RE: Crossroads Mixed Use Filing No. 2 Master Sign Plan, **Re-Submittal**

The Crossroads Comprehensive Sign Guidelines document is being re-submitted to address your review comments dated 3/31/2023.

CROSSROADS

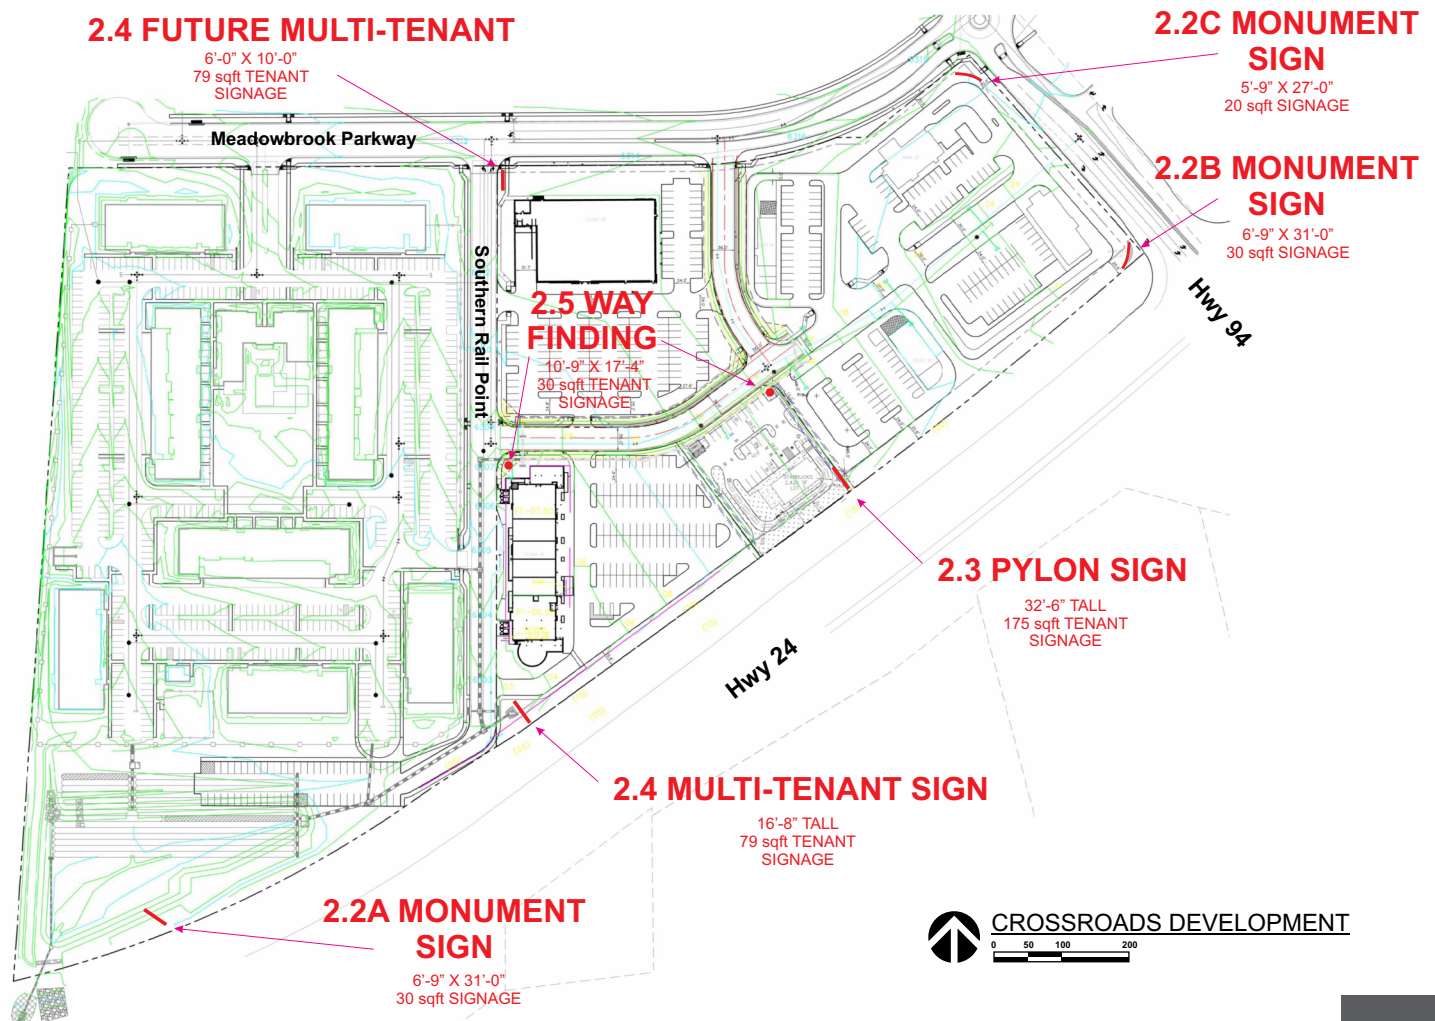
Notes from Page 6.

Signs appear to be within the 20' and 30' foot access and sanitary sewer easement (Rec. No. 217713939) (Plat # 14975).

Signs must be moved outside of easement or applicant must obtain written permission from easement holder to install signs in proposed location.
